Appeal Decision

Appeal Ref: APP/Z4718/D/25/3368887

22D Howgate Road, Slaithwaite, Huddersfield HD7 5AY

- The appeal is made under section 78 of the Town and Country Planning Act 1990 (as amended) against a refusal to grant planning permission.
 - The appeal is made by Mr and Mrs A Schofield against the decision of Kirklees Metropolitan Council.
 - The application reference is 2025/62/90468/W.
 - The development proposed is the erection of an extension.
-

Proposed front/north west facing elevation (1:100)

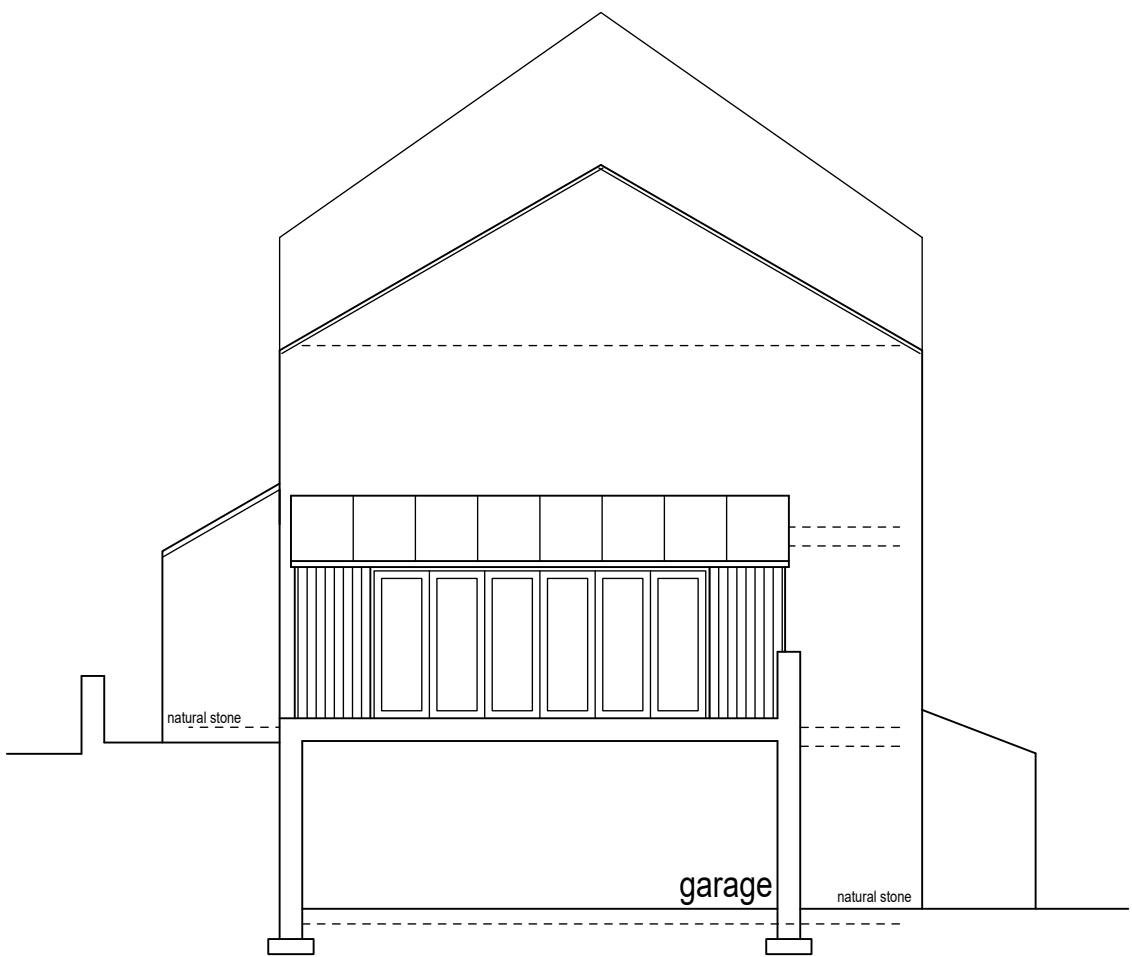
4. The proposed front extension would be single storey and include a mono-pitched roof. It has been carefully designed with a new front door, window and external materials to match those of the host building. Nevertheless, the new addition would project noticeably forward of the main 2-storey front wall and so infill a significant portion of the front garden. By extending across almost the full width of the host building, the proposal would also be a sizeable addition.

5. By disrupting the largely flat front of the existing house, unduly disturbing the unassuming, balanced front façade of the host building, and drawing the dwelling closer to the adjacent footway, the appeal scheme would detract from the character and appearance of the appeal property. As the only example of such development within the same terrace as No 22D and in the street scene to which it belongs, the proposal would draw the eye as a non-original, obtrusive and discordant element.

Proposed ground floor layout (1:100)

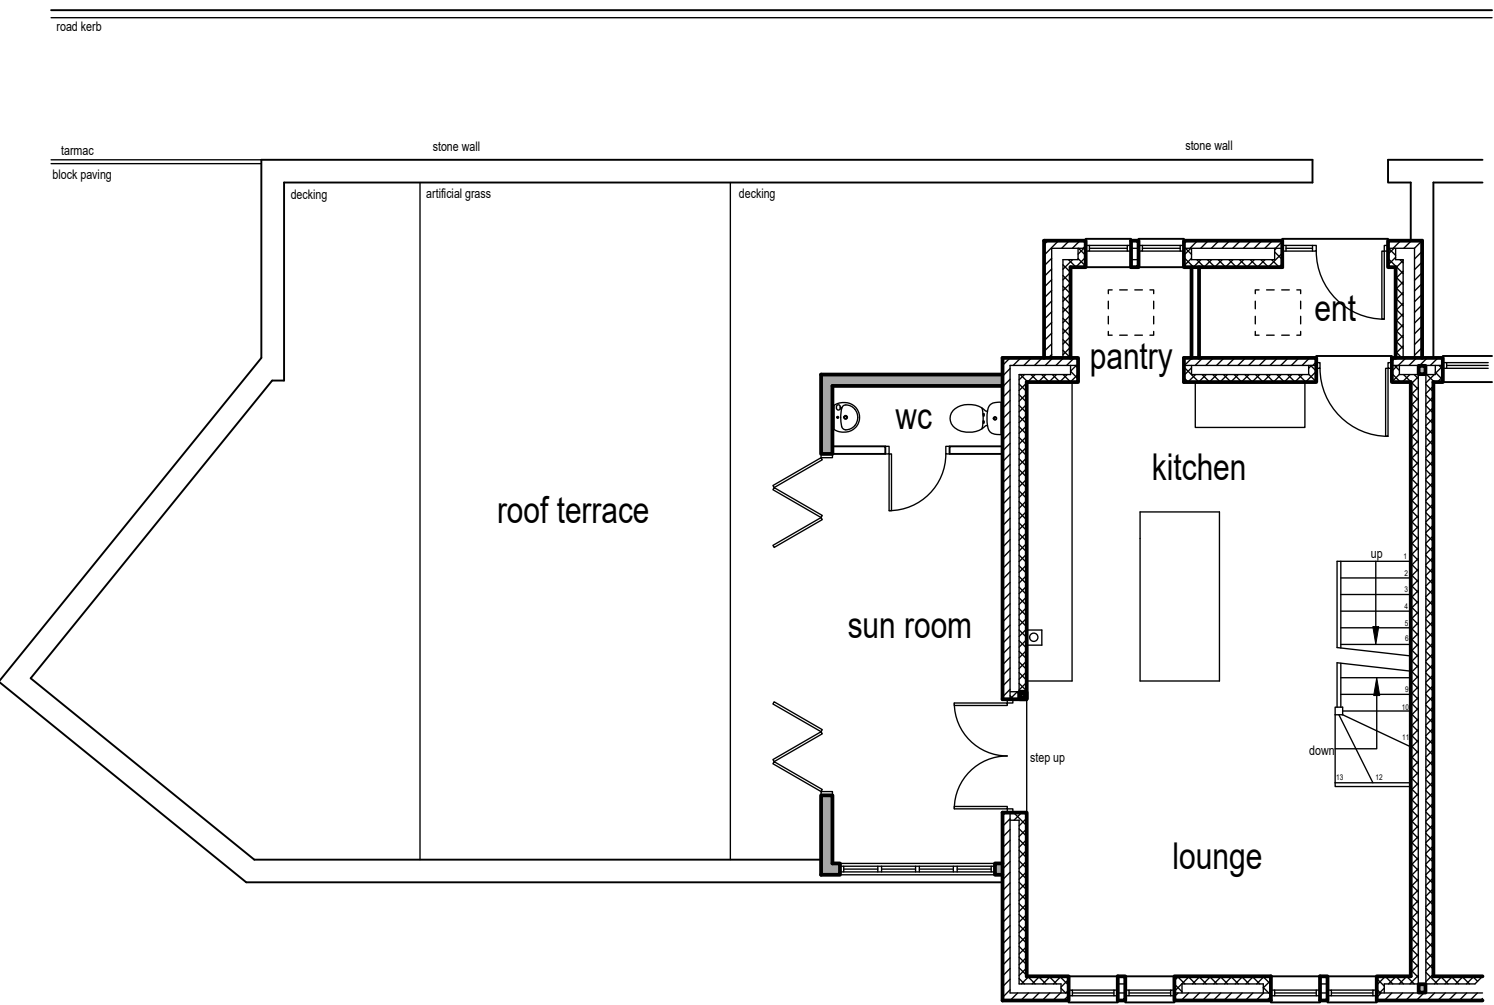
11. The proposal would make efficient use of space available at the front of the house, which the appellants regard to be unusable. Once complete, the new extension would separate the front entrance and the kitchen and provide space for a pantry. In doing so, the proposal would enhance the living conditions of the appellants. Others raise no objection. However, these considerations do not outweigh the significant harm that I have identified.
